M42 Junction 6 Development Consent Order Scheme Number TR010027

8.98 Applicant's Comments on any Additional Information or Submissions Received by Deadline 8

**Applicant's Comments on any Additional Information or Submissions
Received by Deadline 8**

Version	Date	Status of Version
1	15 November 2019	Final for submission at Deadline 9

Figure 7.5: 2021 and 2041 peak hour differences (DS-DM)

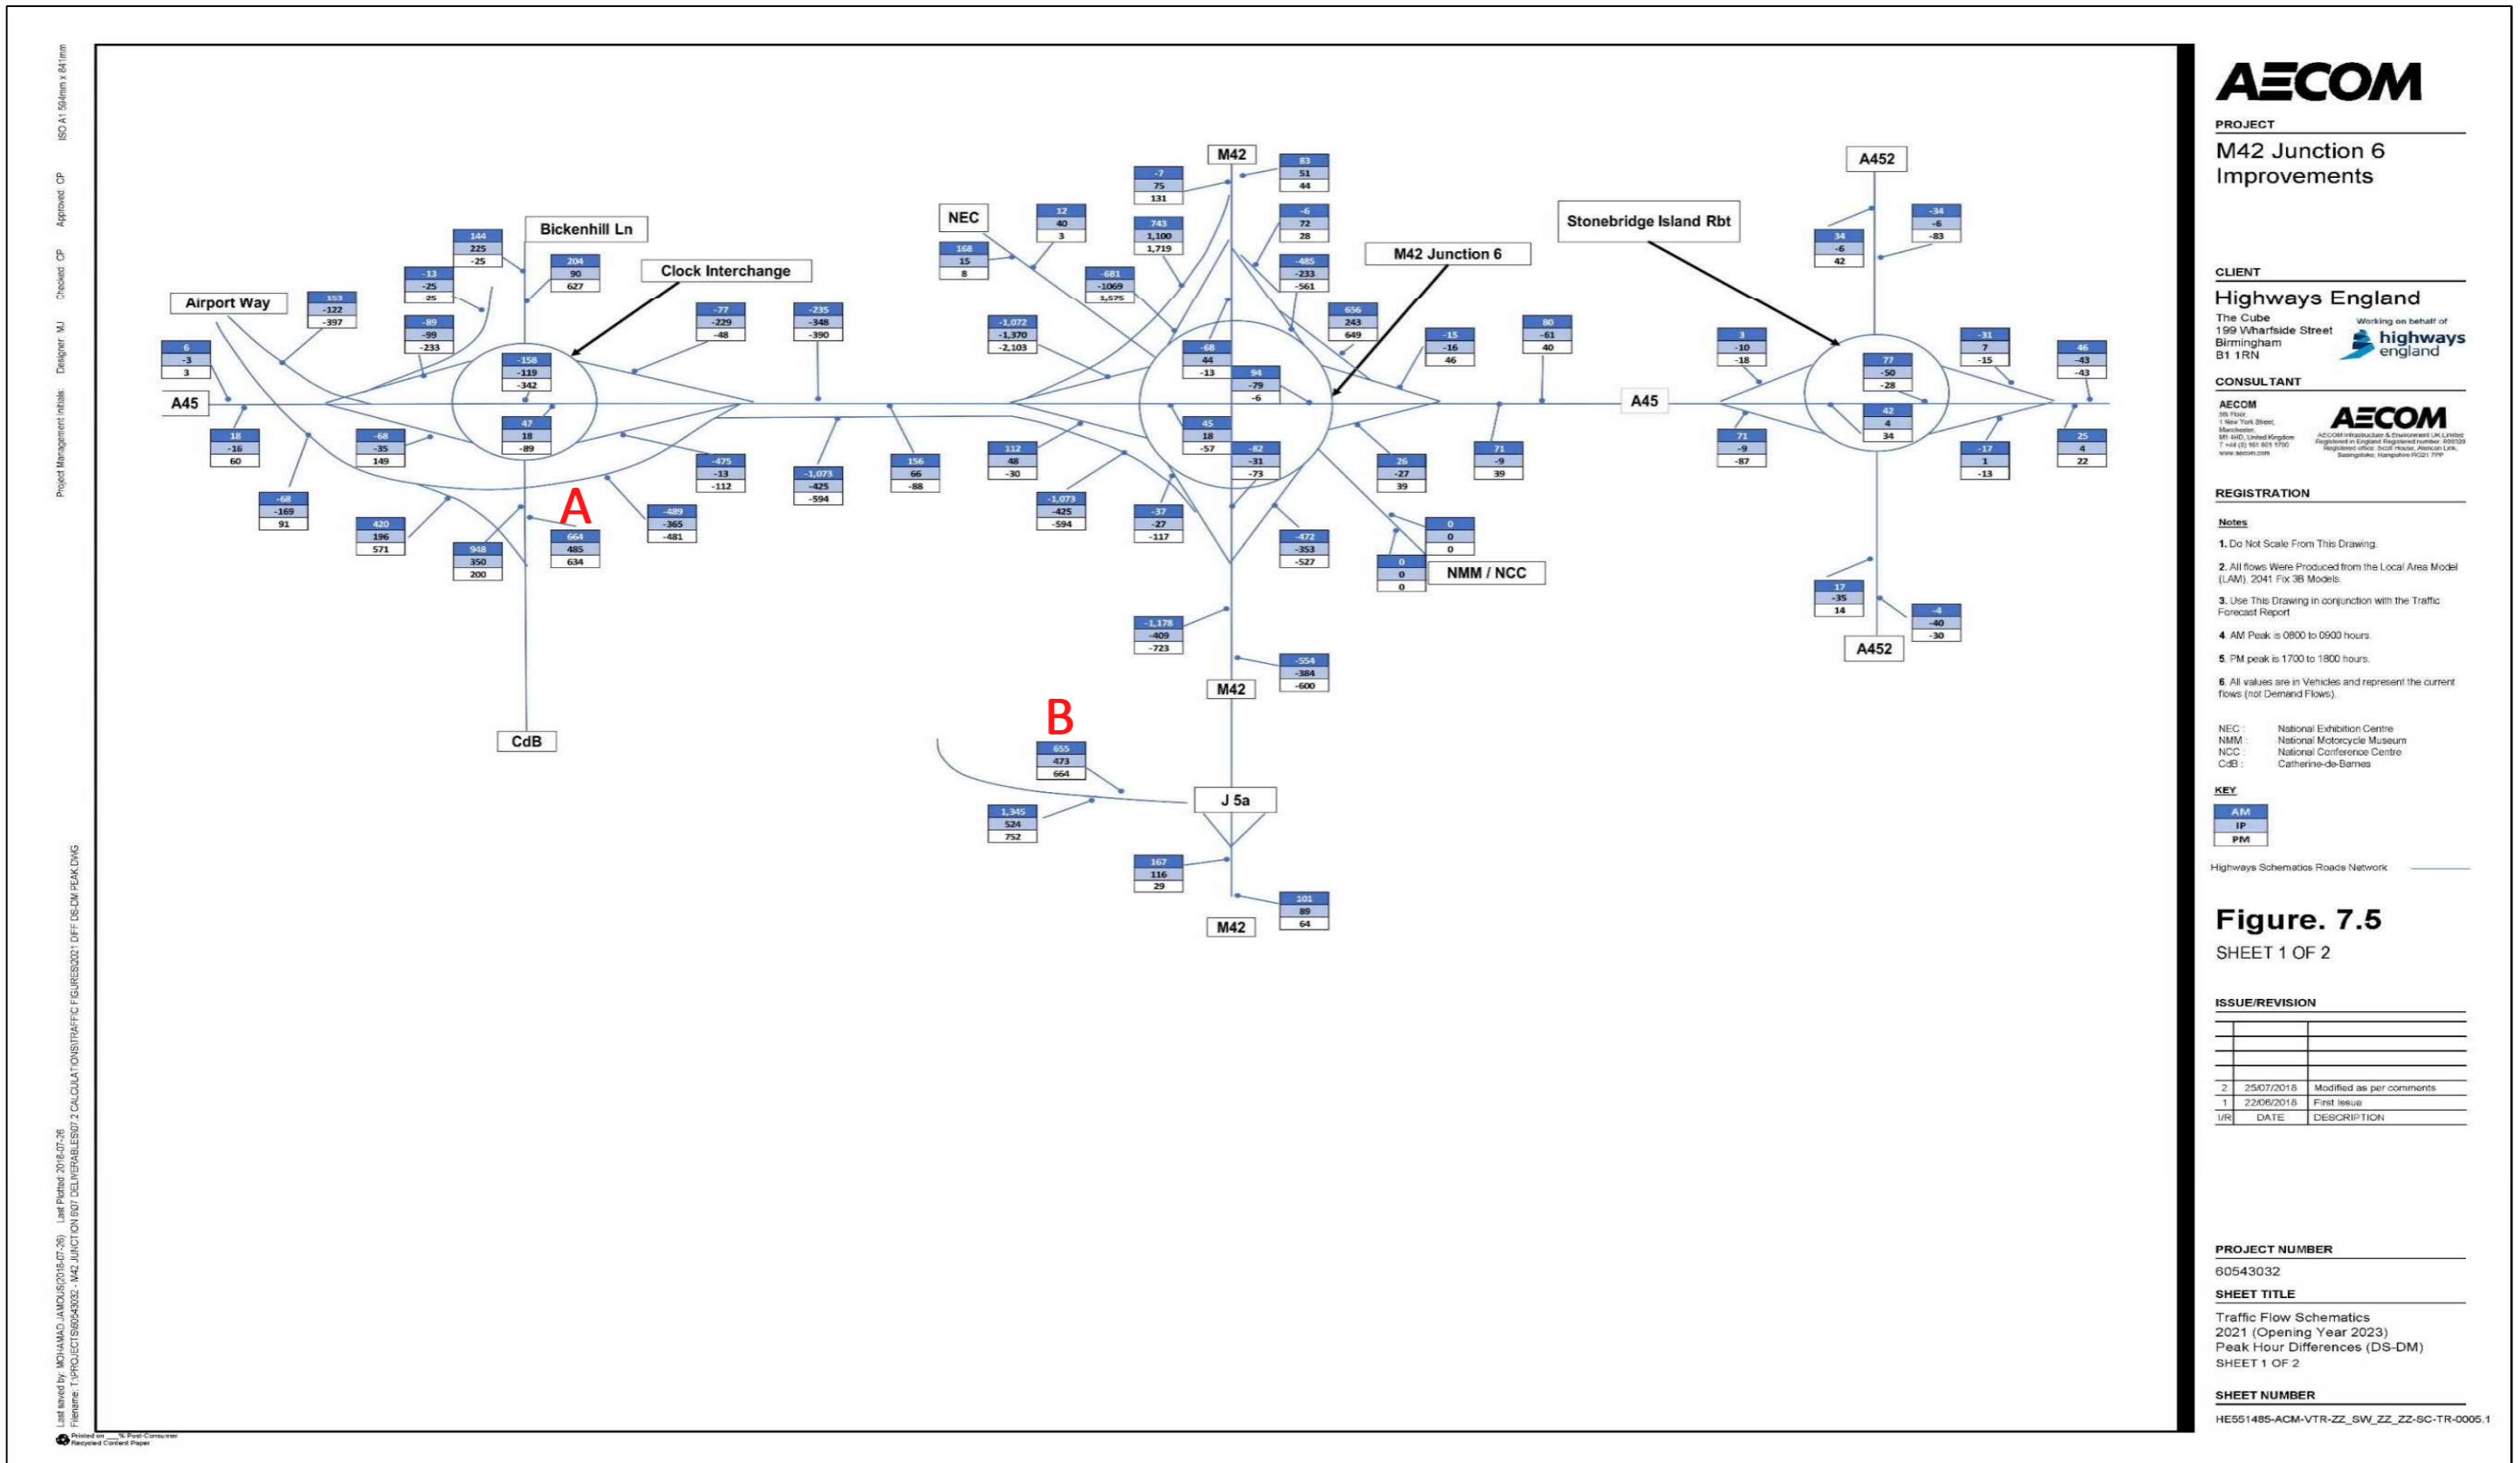
<p>- Unfortunately Figure 7.5 omits the works between Clock Interchange and Hampton Lane Roundabout but does include Junction 5a</p> <p>- In 2021, during AM hours, 664 more vehicles will exit Clock Interchange traveling south and 655 of these vehicles will continue onto the Mainline Link road. It appears there will only be an increase of 9 vehicles using the Realigned Catherine de Barnes Lane in 2021 during AM hours</p>	Year	(A) Southbound on Catherine de Barnes Lane from Clock Interchange		(B) Southbound on Mainline Link road to Junction 5a		2021	2041	2021	2041	AM	664	1315	655	1010	IP	485	879	473	878	PM	634	730	664	512
Year	(A) Southbound on Catherine de Barnes Lane from Clock Interchange			(B) Southbound on Mainline Link road to Junction 5a																						
	2021	2041	2021	2041																						
AM	664	1315	655	1010																						
IP	485	879	473	878																						
PM	634	730	664	512

Submitted by	Title	Comments												
		<p>- In 2021, during PM hours, 634 more vehicles will exit Clock Interchange traveling south but 664 vehicles will continue onto the Mainline Link road. Where have the extra 30 vehicles come from?</p> <p>- In 2041, during AM hours, 1315 more vehicles will exit Clock Interchange traveling south and 1010 of these vehicles will continue onto the Mainline Link road. It appears there will be an increase of 305 vehicles using the Realigned Catherine de Barnes Lane in 2041 during AM hours</p> <p>- In 2041, during IP hours, 879 more vehicles will exit Clock Interchange traveling south and 878 of these vehicles will continue onto the Mainline Link road. It appears there will only be an increase of 1 vehicle using the Realigned Catherine de Barnes Lane in 2041 during IP hours</p> <p>- In 2041, during PM hours, 730 more vehicles will exit Clock Interchange traveling south and 512 of these vehicles will continue onto the Mainline Link road. It appears there will be an increase of 218 vehicles using the Realigned Catherine de Barnes Lane in 2041 during PM hours.</p> <div data-bbox="772 792 1808 1170" style="border: 1px solid black; padding: 5px;"> <p>Figure 7.6 – AADT 24hr Flows Differences (DS-DM) (2021 and 2041)</p>

Submitted by	Title	Comments
		<p>- In 2041, 12953 more vehicles will exit Clock Interchange traveling south and 11275 of these vehicles will continue onto the Mainline Link road. It appears there will be an increase of 1678 vehicles using the Realigned Catherine de Barnes Lane in 2041</p> <p>Given the above it is difficult to conclude that Highways England are correct when stating the annual average daily Traffic Flow southbound to Catherine-de-Barnes Lane shall be 8,532 under the do minimum scenario compared to 8,348 under the do something scenario.</p> <p>In fact, it is glaringly obvious that they have simply cherry-picked data in an attempt to justify their argument.</p> <p>It also appears that their Traffic Flow data is seriously flawed.</p> <p>As HE have used this flawed Traffic Flow data in their air quality assessment document 'TR010027-000139-TR010027_M42J6_6-1_Environmental_Statement_Chapter_6' and noise assessment document 'TR010027-000145-TR010027_M42J6_6-1_Environmental_Statement_Chapter_12' one must assume that these documents are not a true reflection of the impact of the scheme and they must be updated accordingly before any decision is made by the ExA.</p> <p>The Applicant comment:</p> <p>The Applicant's response to Action point 20 within Volume 8.86 [REP7-011/Volume 8.86] referred to southbound traffic along Catherine-de-Barnes Lane where it reaches Catherine-de-Barnes roundabout, not where it will reach the new Barber's Coppice roundabout. This is because the Applicant is of the view that this is the area currently most susceptible to the congestion described by Mr O'Reilly.</p> <p>Mr O'Reilly's subsequent comments largely relate to the traffic flow numbers not 'adding up' between road sections within the Transport Assessment Report (TAR) [APP-174/Volume 7.2]. The comments also question the validity of the traffic flow data which has been used to inform the air quality and noise assessments.</p> <p>The Applicant can confirm that the traffic flows presented in Figures 7.1 to 7.6 of the TAR provide a summary of the forecast flows produced by the M42 Junction 6 Local Area Model (LAM). As the figures referred to by Mr O'Reilly are summary figures, these do not provide flow information for</p>

Submitted by	Title		Comments
			<p>every road section which is why the totals do not add up and are not meant to. The Applicant's selection of links was made to simplify the presentation of the flows while allowing some comparisons to be made between forecast years and scenarios. The full information is contained in the LAM and informed both the traffic and environmental assessment, including the assessments of air quality and noise.</p>
Philip O'Reilly	Response to action points: ISH 7 on the draft Development Consent Order – 23 rd October 2019	16	<p>Philip O'Reilly comment:</p> <p>I can confirm a letter from Chris Harris (Highways England) was attached to an email received from Lydia Barnstable (AECOM) on 25th October 2019 and marked 'Private and Confidential'. However, it does not address the concerns I have raised. In short:</p> <ul style="list-style-type: none"> - The letter advises that I should engage a professional advisor but does not confirm that Highways England will meet the cost. - The letter confirms that works will be undertaken but does not provide any information or plan showing the extent of those works. - It is disappointing to say the least that Highways England are still unable to confirm how my property is affected by their scheme. - The letter does not confirm how the main access and the rear access to my property will be treated. - Instead of agreeing any fencing or boundary treatment to my property directly with Highways England it will need to be agreed with the Principal Contractor. - Although the works in front of my property have not changed a great deal since January 2018 Highways England have still not completed the Land Registry checks (but advise that they will be completed by 2nd November 2019) and therefore cannot confirm what land will revert to my ownership under the ad medium filum rule. No information has been provided prior to Deadline 8. - I would prefer to have control, and therefore ownership, of as much of the land outside the current boundary to my property up to the realigned Catherine de Barnes Lane to ensure it is properly maintained.

Figure 7.6: AADT 24hr flows differences (DS-DM)

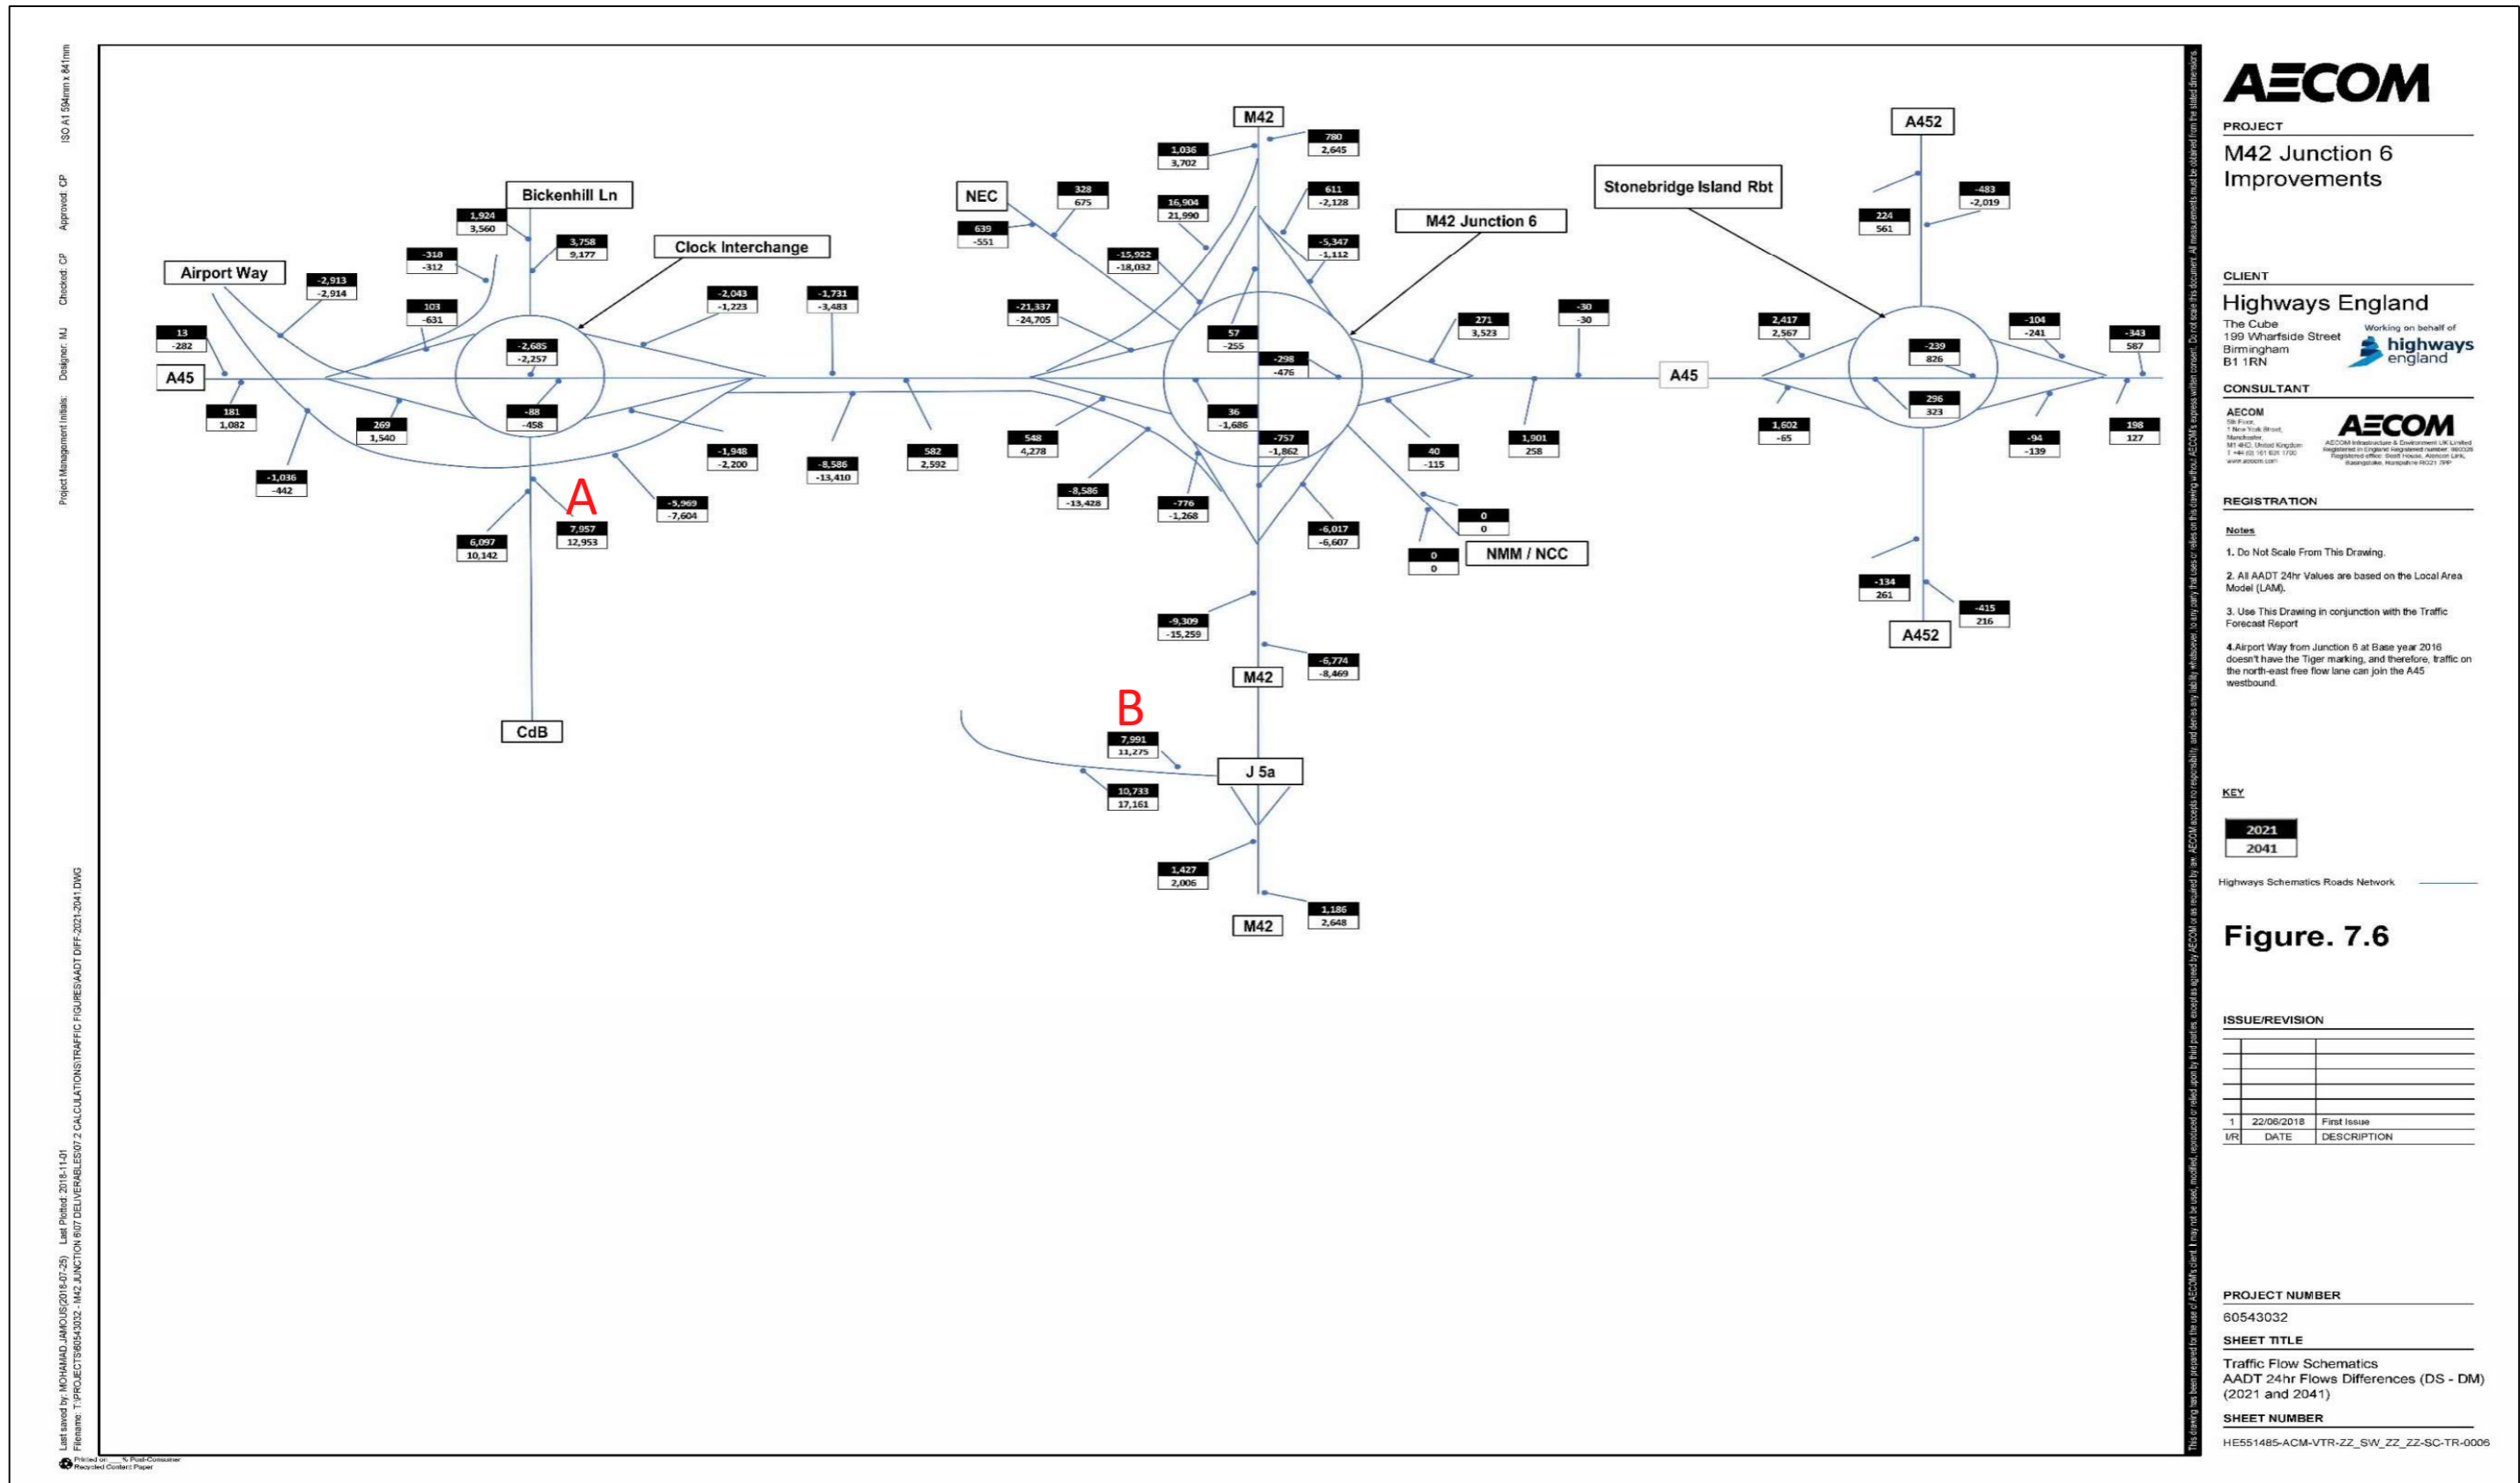
</div> <p>- Unfortunately Figure 7.6 omits the works between Clock Interchange and Hampton Lane Roundabout but does include Junction 5a</p> <p>- In 2021, 7957 more vehicles will exit Clock Interchange traveling south and 7991 of these vehicles will continue onto the Mainline Link road. Where have the extra 34 vehicles come from?</p>		(A) Southbound on Catherine de Barnes Lane from Clock Interchange	(B) Southbound on Mainline Link road to Junction 5a	Year	Difference	Difference	2021	7957	7991	2041	12953	11275
	(A) Southbound on Catherine de Barnes Lane from Clock Interchange	(B) Southbound on Mainline Link road to Junction 5a												
Year	Difference	Difference												
2021	7957	7991												
2041	12953	11275
